Recommendation Report for Planning Permission for Works or Extension to a Dwelling

REF NO: BN/52/19/HH

LOCATION: Brook Cottage  
Lake Lane  
Barnham  
PO22 0AD

PROPOSAL: Ground and first floor rear extension and alterations.

DRAWING 2A

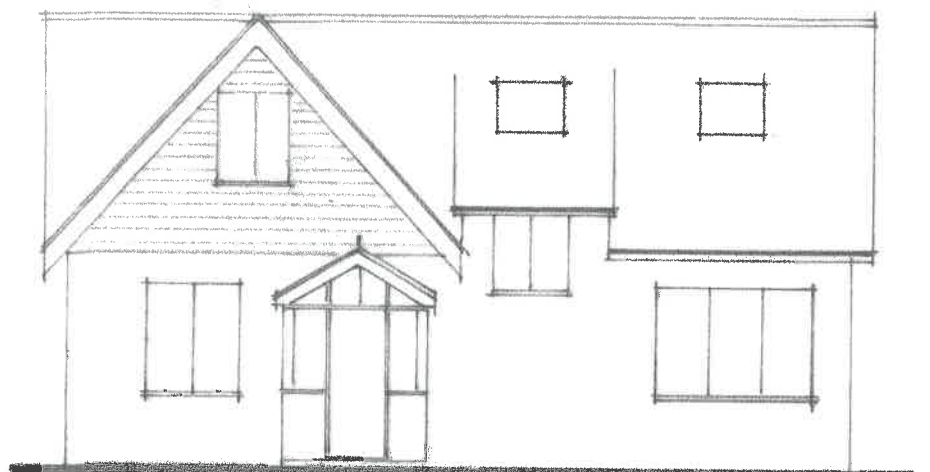
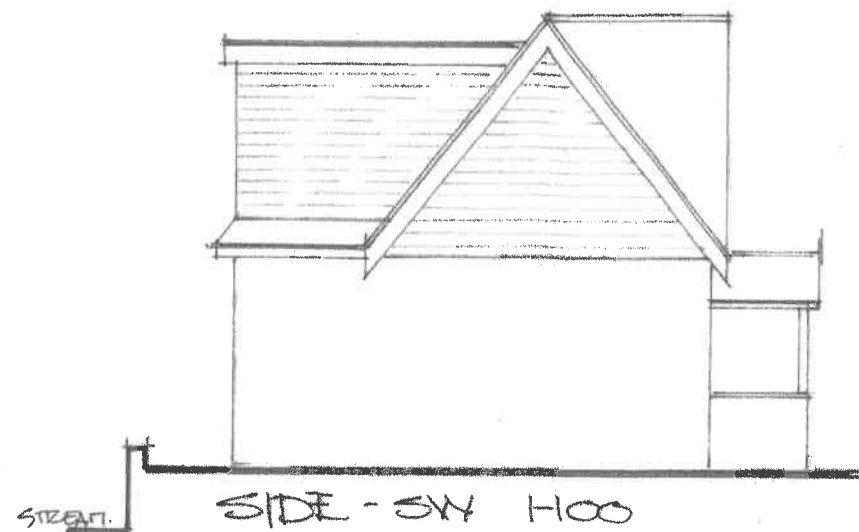
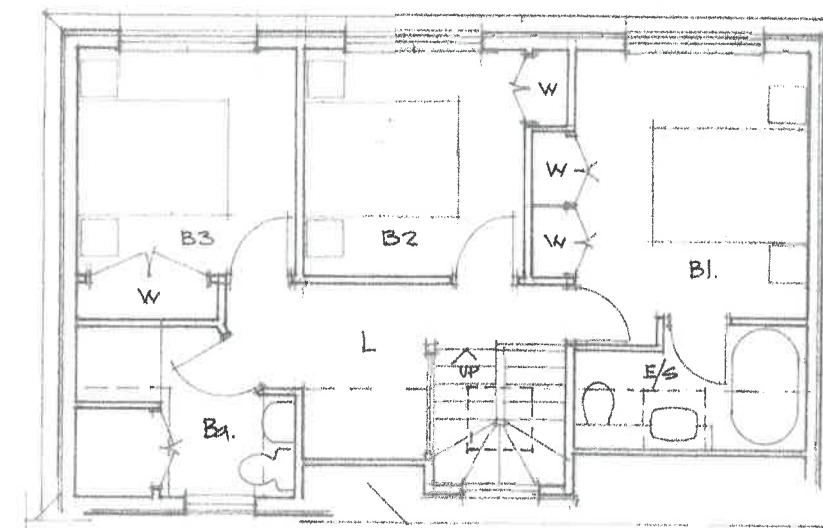
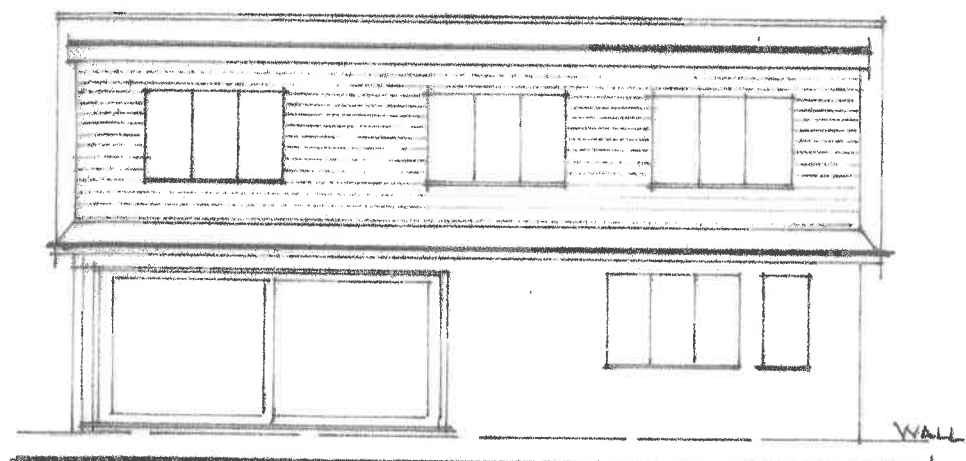
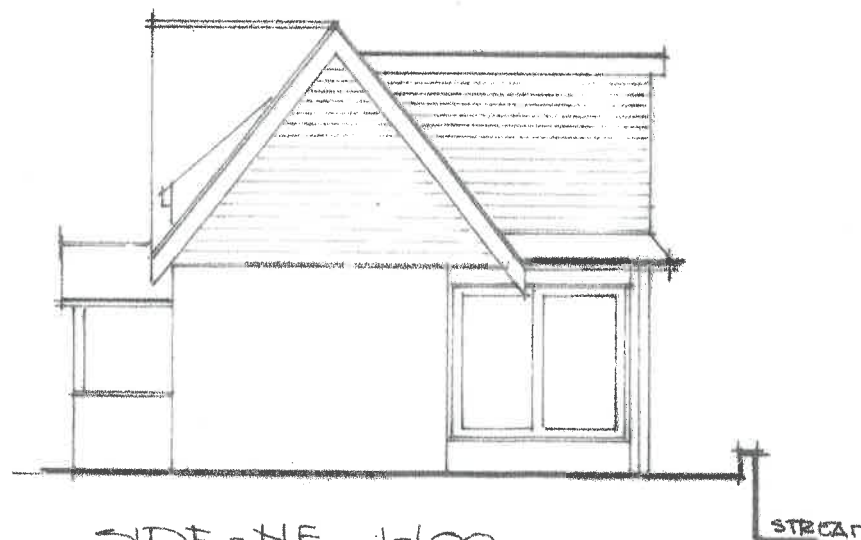
The proposal will construct a gable end to the south west. This will allow for the erection of a dormer to the rear. The roof alteration will therefore be visible from the front elevation. A window will also alter to the front which will be repositioned slightly higher to serve a staircase.

The rear has an existing gable addition. This will alter which will allow for a dormer to be constructed along the rear roof slope. It will run along the full rear with length of 10.3m with a height of 2.4m. Whilst it adds bulk to the rear of the property it is not considered to appear adversely overbearing or overshadowing.

SITE PLAN
1:250.

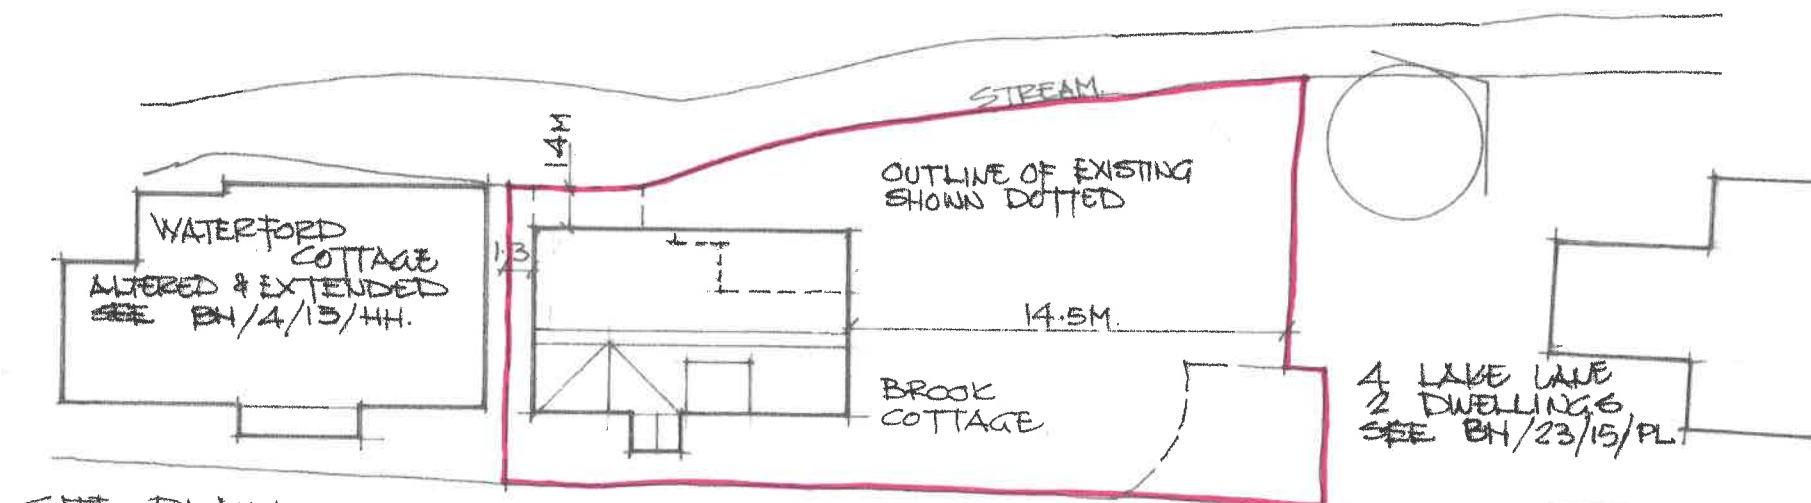
It appears from the site drawings that although this is a proposal for an extension of the property, that the footprint of the building in relation to the stream is actually reduced with the rear ground floor protrusion to the stream bank top being removed. This being the case the applicant should ensure that during construction no materials are allowed to enter the

watercourse and the retaining bank of the stream should be left as natural as possible, to provide a suitable buffer and wildlife corridor. Ideally this buffer should be left to naturally colonise, but if planting is required then only naturally occurring native species should be considered.
